# **M3 Junction 9 Improvement**

**Scheme Number: TR010055**

## **5.1 Consultation Report Appendix E - EIA Scoping**

# **SCOPING OPINION:**

DRAWING TITLE  
FIGURE 2.5 - THE SCHEME: TEMPORARY TRAFFIC DIVERSION ROUTES  
APFP REGULATIONS 5(2)(a)  
SHEET 5 OF 12  
DOCUMENT REFERENCE 6.2

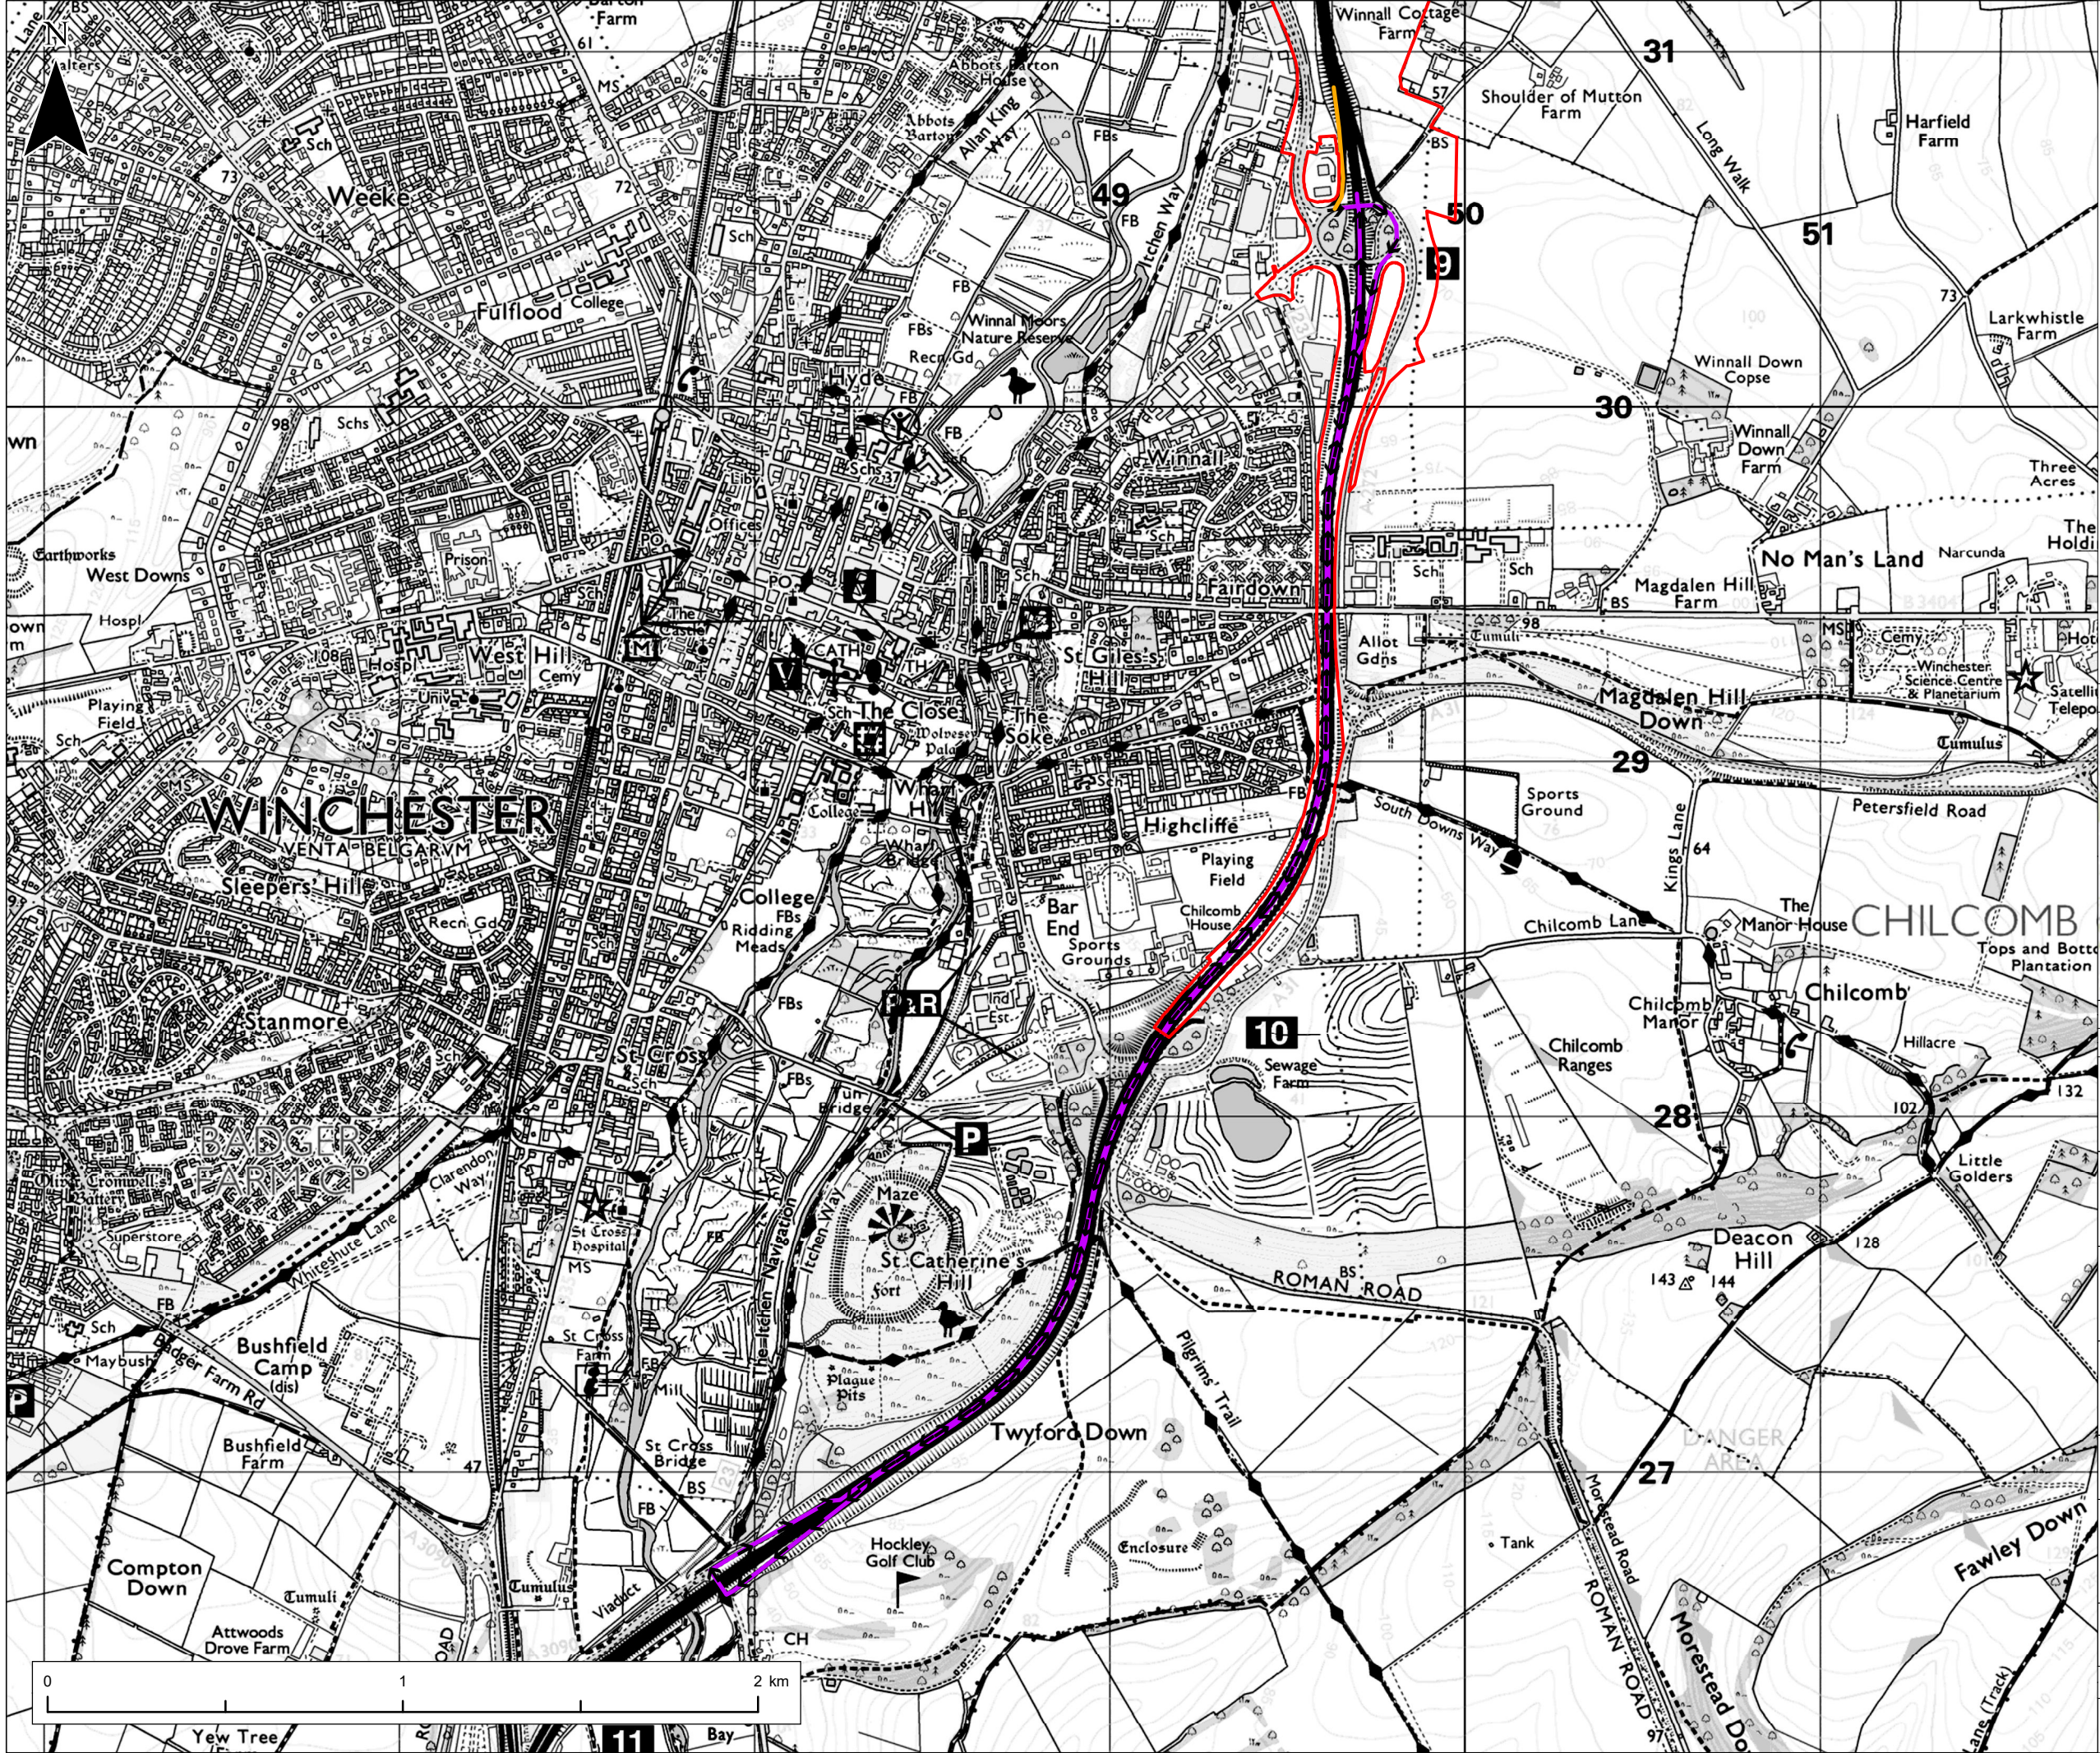
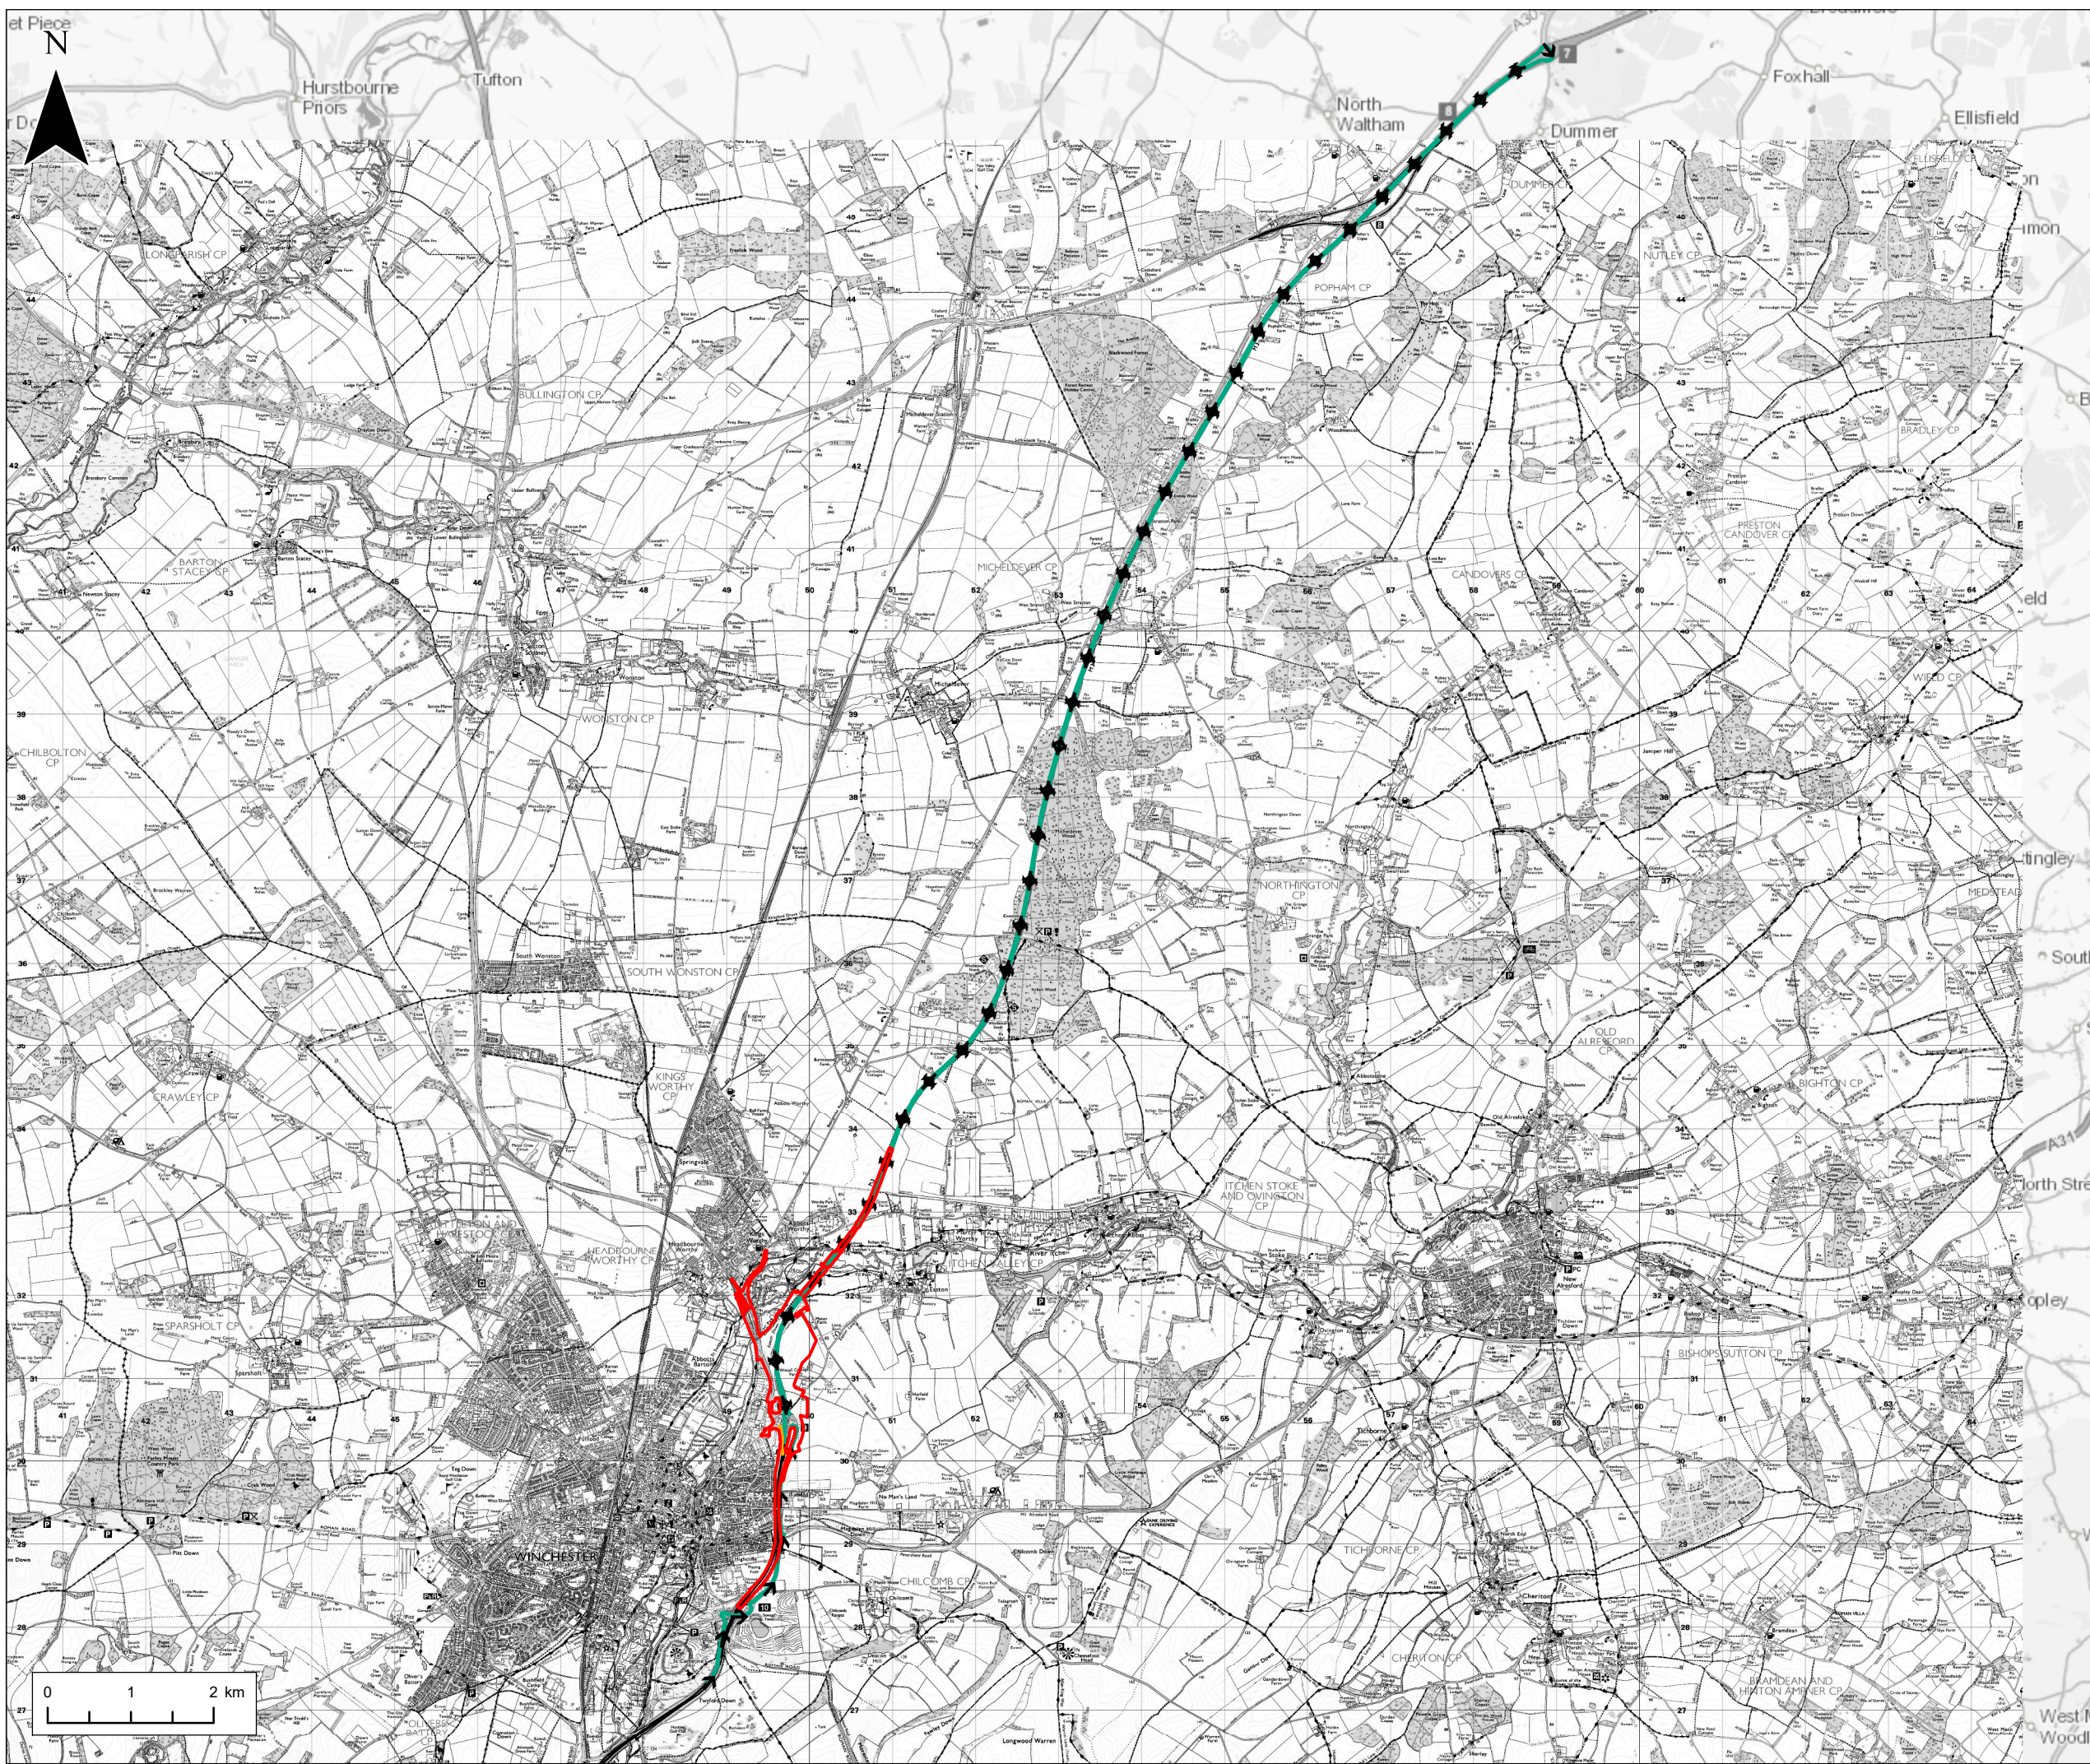
- 2.3.7 Diversions and closures of roads are listed to be required throughout in the construction phase. The ES should contain a full explanation of such closures and diversions, including whether they are temporary or permanent, and associated impacts should be fully assessed. This should also include any closures or diversions to Public Footpaths or Rights of Way.
- 2.3.8 This information should also be depicted on figures in the ES, to provide further clarity.
